Proposal:	Discharge of condition 2 - revised footways and parking bays, 3 - walling and roofing materials, 4 - landscaping and 5 - renewable energy of planning consent 3/2009/0399
Location:	Land adj 34 Kirklands Chipping
Grid Ref:

The Highway Development Control Section has made the following comments regarding the discharge of condition 2 (revised footways and parking bays): -

Client:	KEEPMOAT		
Job:	KIRKLANDS, CHIPPING		
Drawing title:	SITE LAYOUT		
Drawing Number: (Job number)	M3792	100	Revision: C
Scale:	1:100@A1		
Date:	FEB 15		
Drawn by/ checked by:	MCS

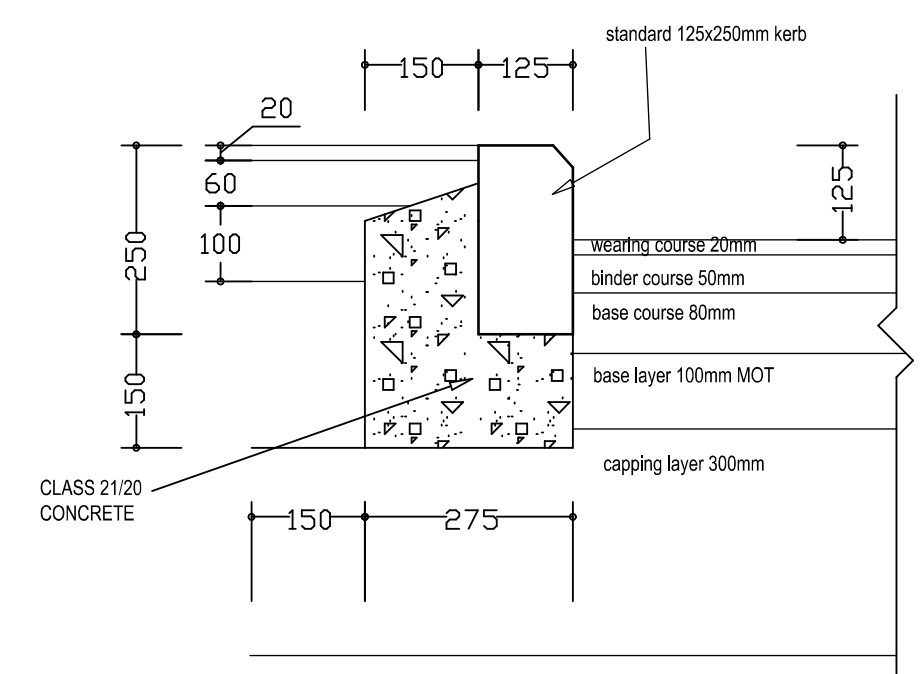
1. The car parking associated with the single car parking space; provide a 3.0x3.0m sight line from the centre of the drive to be back of the footway, to provide safe vision of pedestrians passing the parking bay.
Layout of parking bay revised to reflect, C/B fencing in the visibility splay amended to vertical metal railings.

2. The car parking associated with the single car parking space to have a minimum clear width of 2.6m, to provide additional room to open the doors if fenced in.
Amended to 2.6m wide

3. Each car parking space associated with 14 Club Row to be a minimum of 2.4x4.8m and provide sight lines to allow views of passing vehicles and pedestrians within the forecourt.
This parking area isn't a designated space, more an informal parking space that the occupant of 14 Club Row uses, it was shown as new surface as it is anticipated that remedial works would be required following the new fence and retaining wall works, hatch removed to avoid confusion
